16/03/2020

75-85 Harrington Street Mixed Use Mod 3 (SSD 7037 Mod 3)
Request for Additional Information

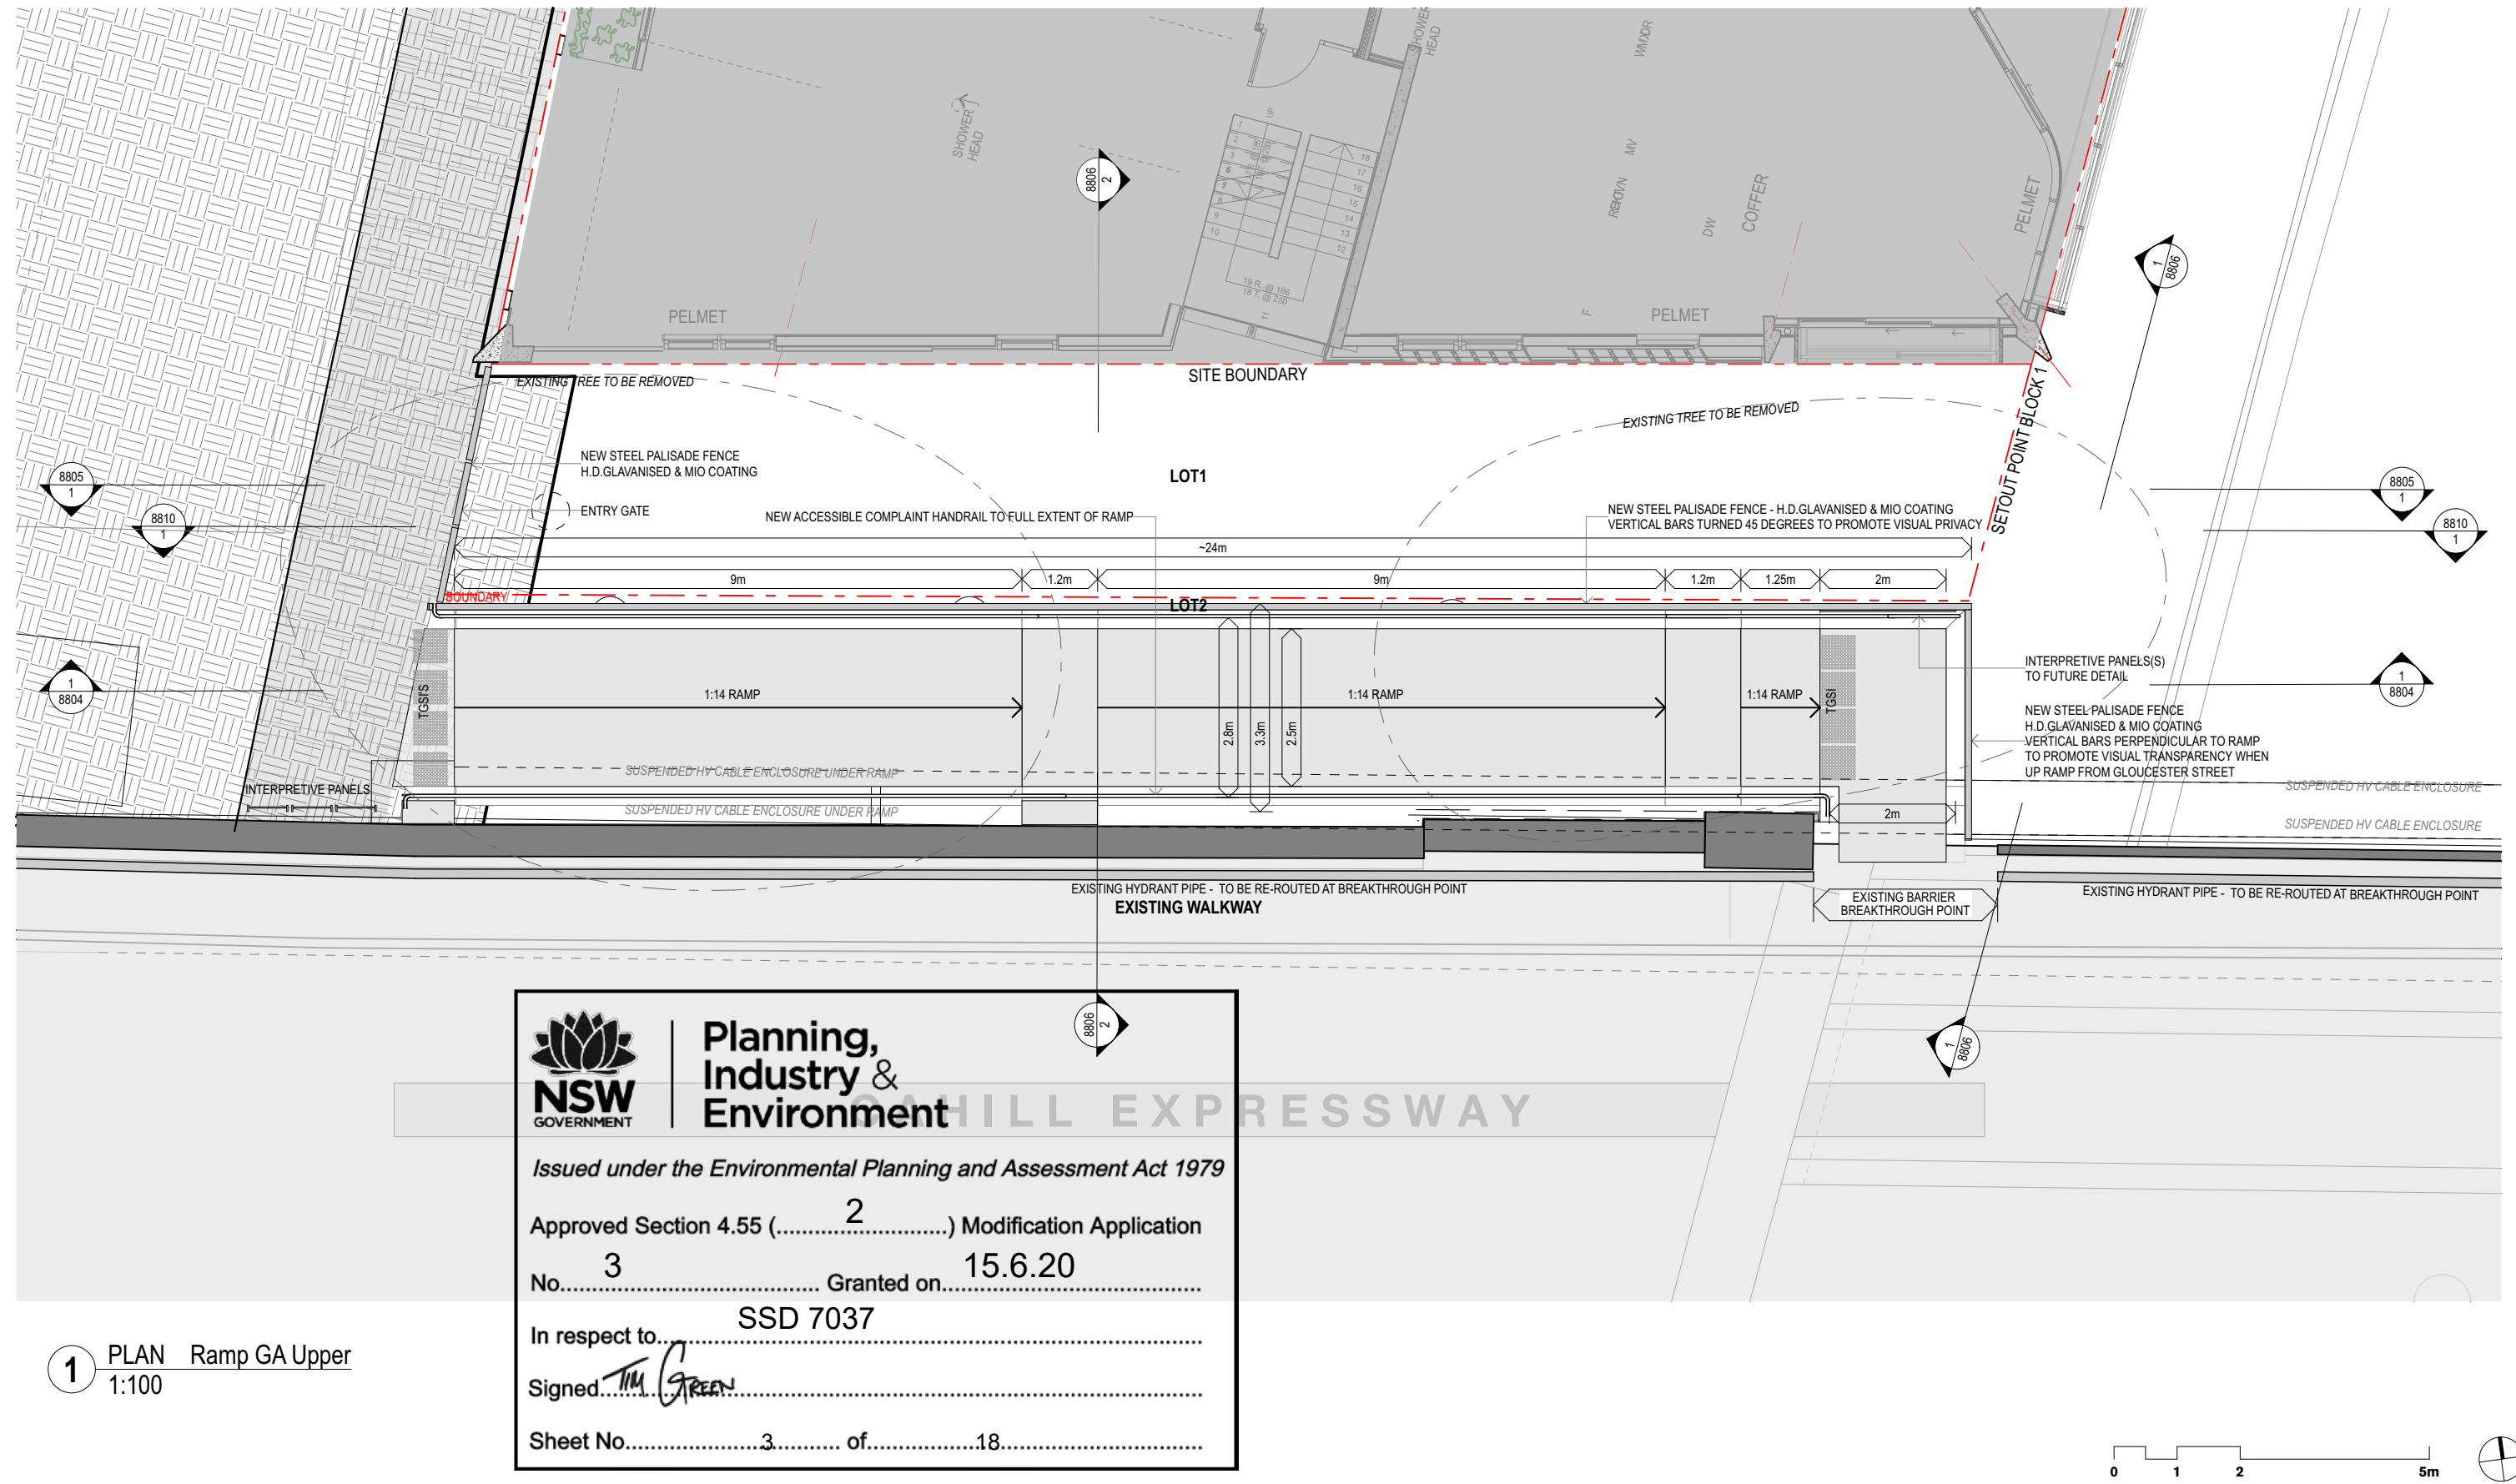
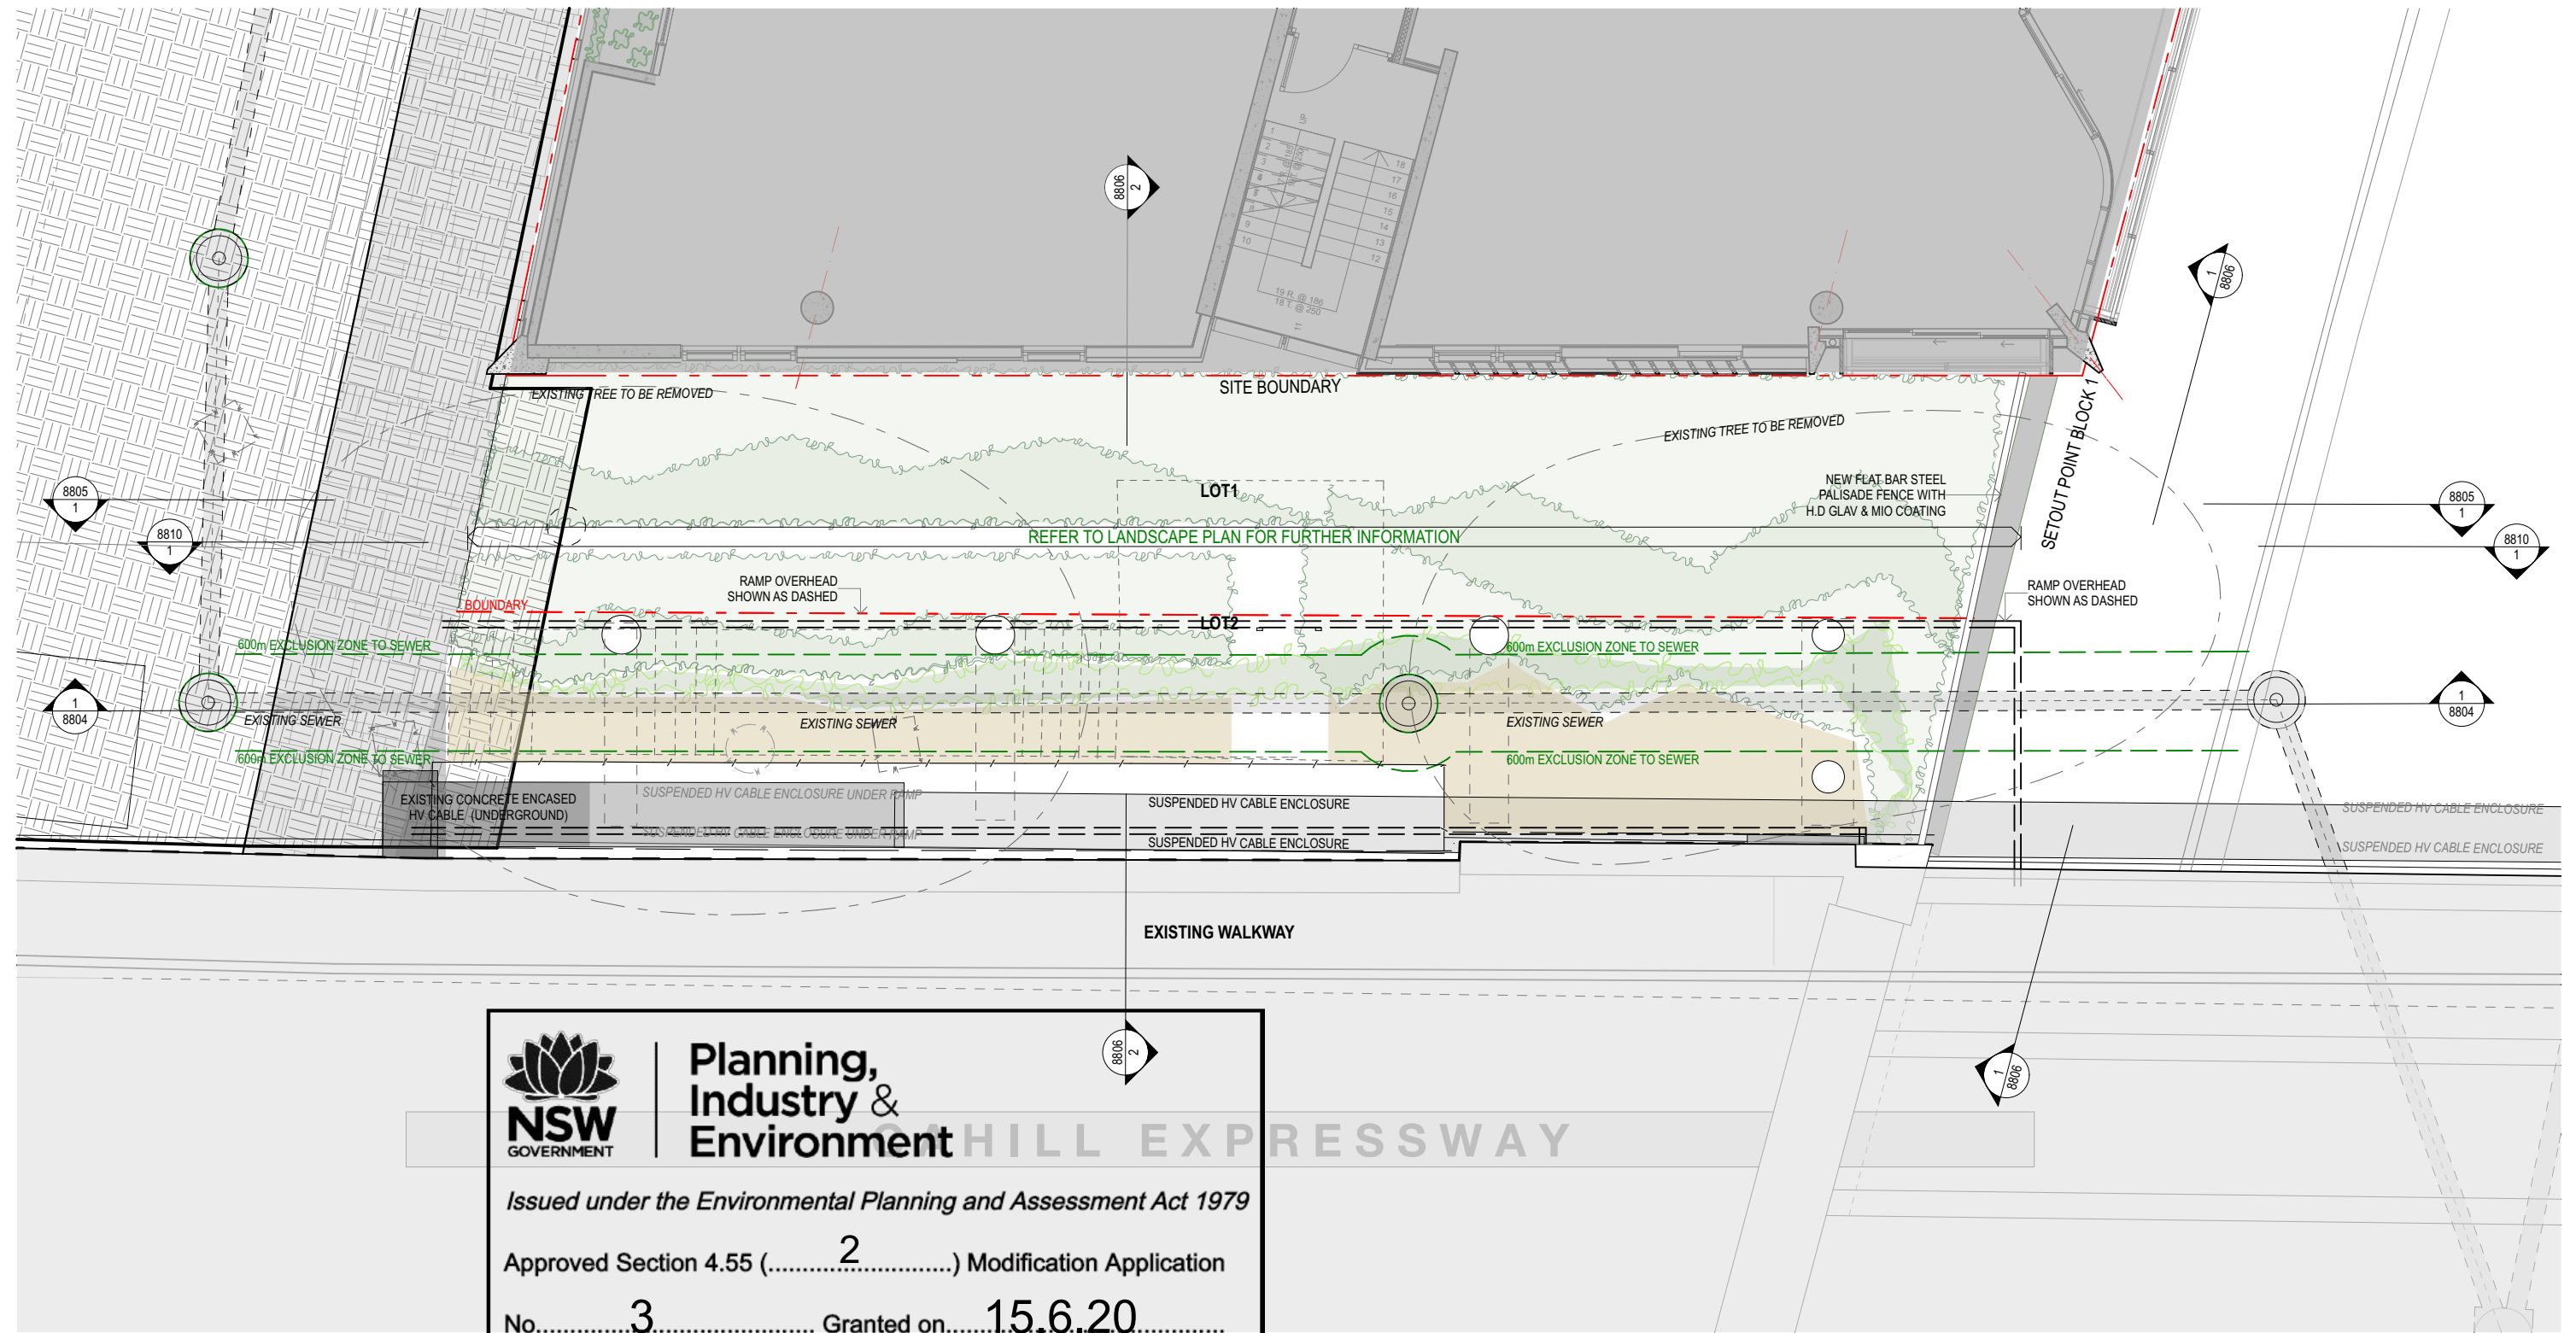
- consideration of the NSW Government's Sydney Access Strategy (2018 update), the City of Sydney's Cycle Strategy and Action Plan 2018-2030 and the need for the ramp to cater for the safe movement of pedestrians and cyclists
- a signage strategy to assist in directing ramp users to and from the public lift located within the approved development, in order to gain access between Gloucester Street to Harrington Street.
